Re: Sawmill Bldg J
800 20th St NW
Traffic Circulation Layout
Engineer's/Architect's Stamp 9-30-24 (J13D076B)

Based upon the information provided in your submittal received 10-1-24, the above referenced plan cannot be approved for Building Permit until the following comments are addressed:

ENGINEER'S SEAL	DRAWN BY SB
	200 20TH ST ALBUQUERQUE, NM	DATE 9-30-24
	CONSTRUCTION DETAILS	DRAWING
	 TERRA WEST, LLC 5571 MIDWAY PARK PL NE ALBUQUERQUE, NEW MEXICO 87109 (505) 858-3100 www.terrawestllc.com	SHEET # DET-1
 RONALD R. BOHANNAN P.E. #7868	9-30-24	JOB # 2022136

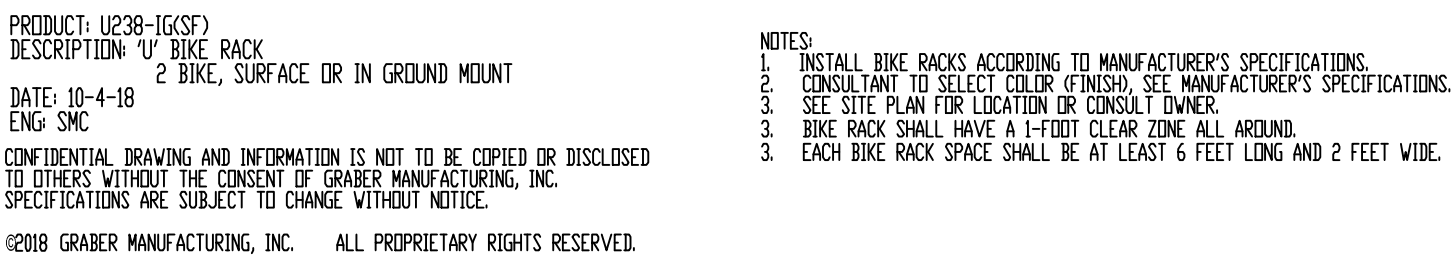
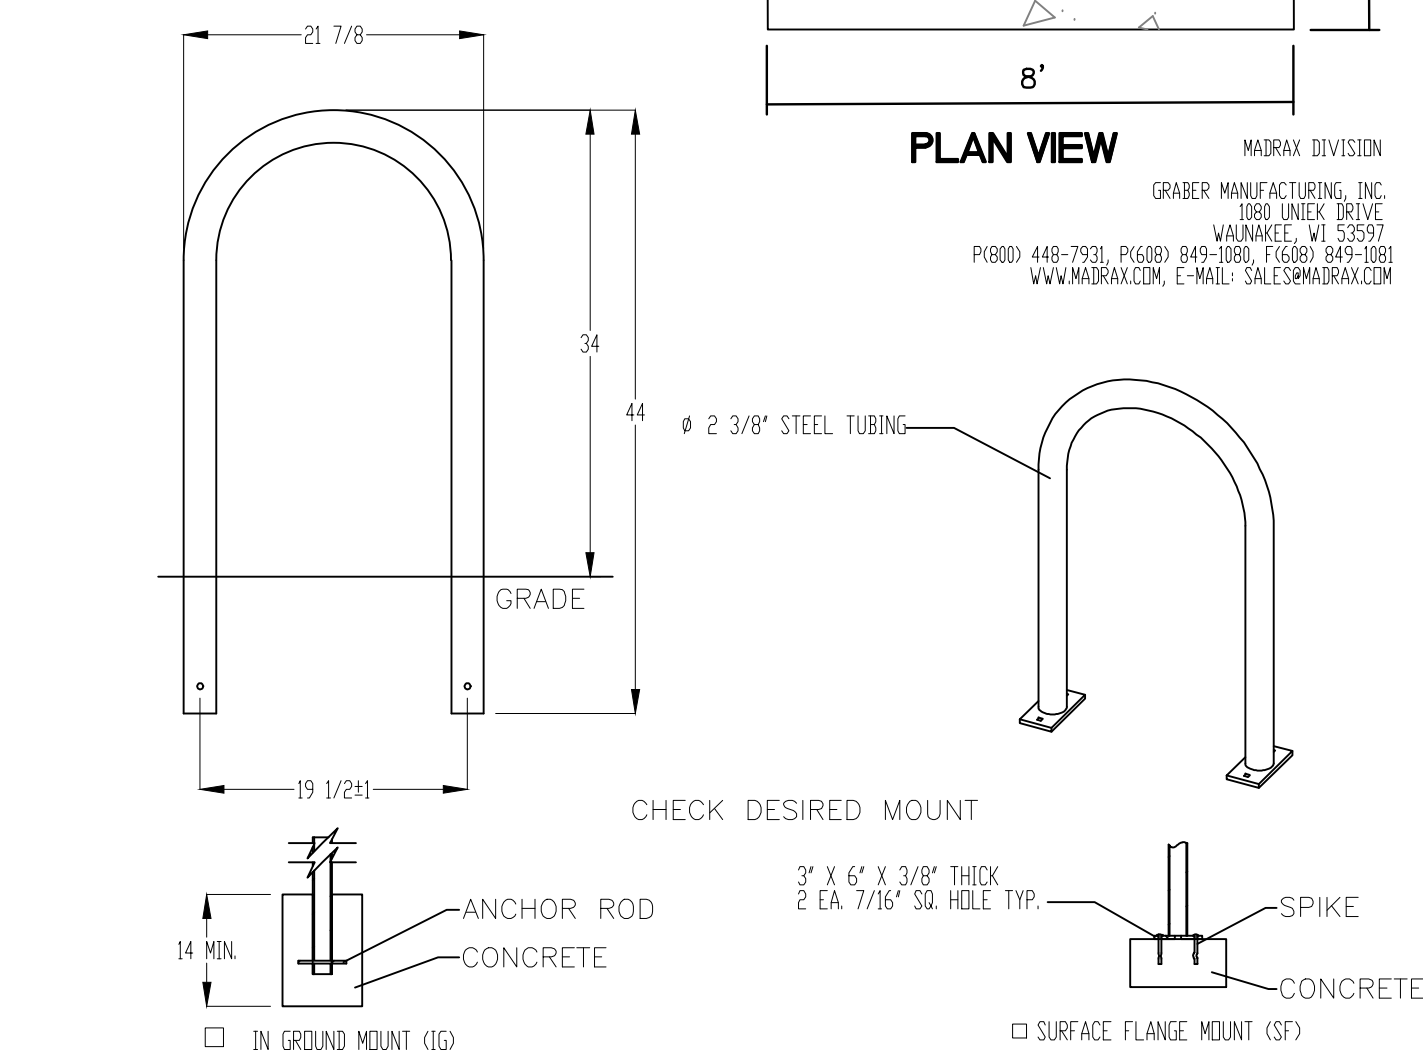
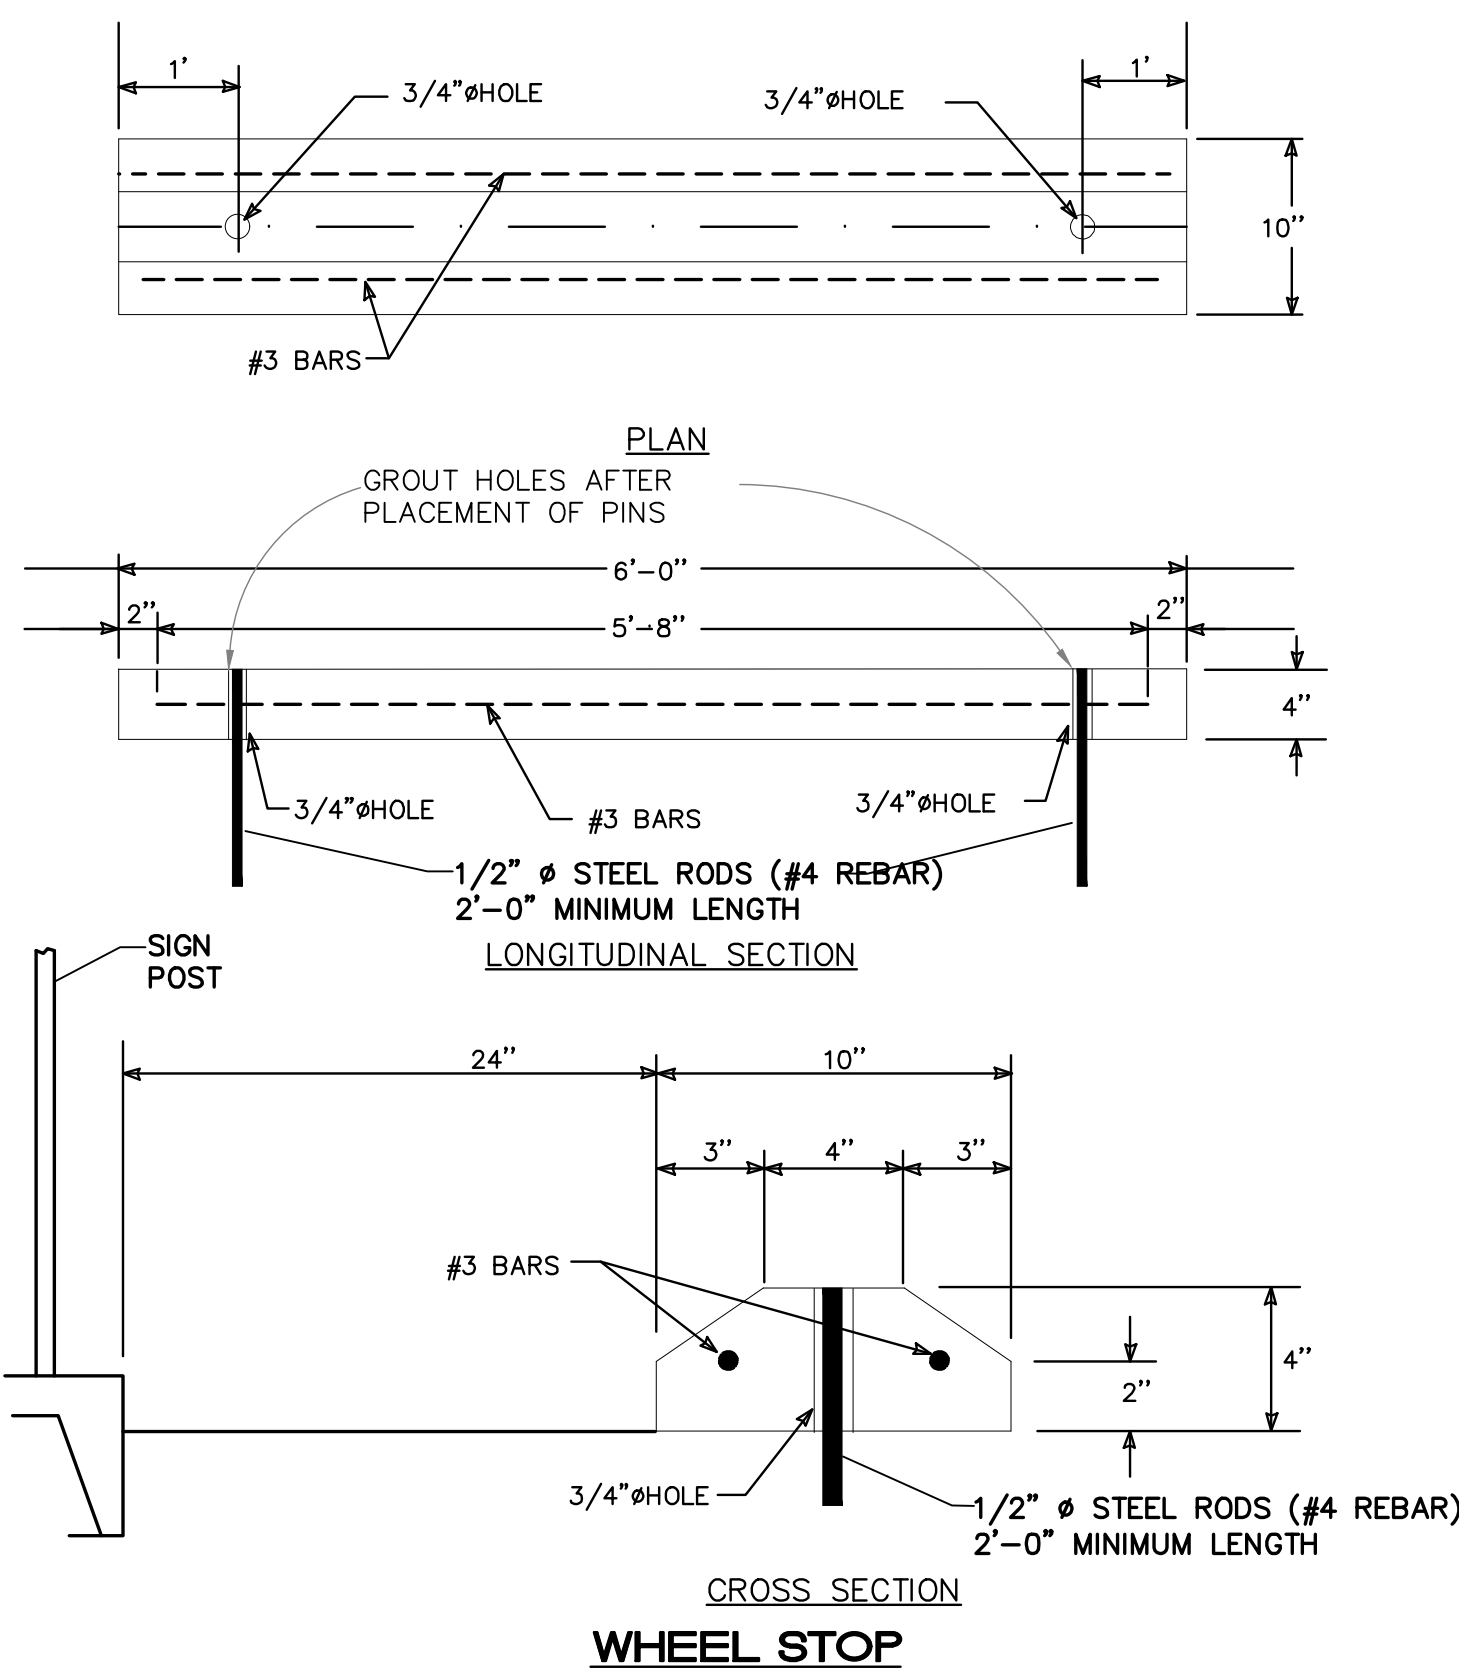
5. Bicycle parking spaces shall be at least 6 feet long and 2 feet wide. Revise your details to reflect the spacing.

6. Show all drive aisle widths and radii. Some dimensions are not shown.
7. Per the DPM, a 6 ft. wide ADA accessible pedestrian pathway is required from the public sidewalk to the building entrances. Please clearly show this pathway and provide details as keyed noted #14.
8. Show the existing sidewalk and buffer widths along 20th st on the plan.
9. Provide approval of solid waste dept. and fire marshal.
10. Please fill out the attached TSF and submit it to Curtis Cherne CCherne@cabq.gov.
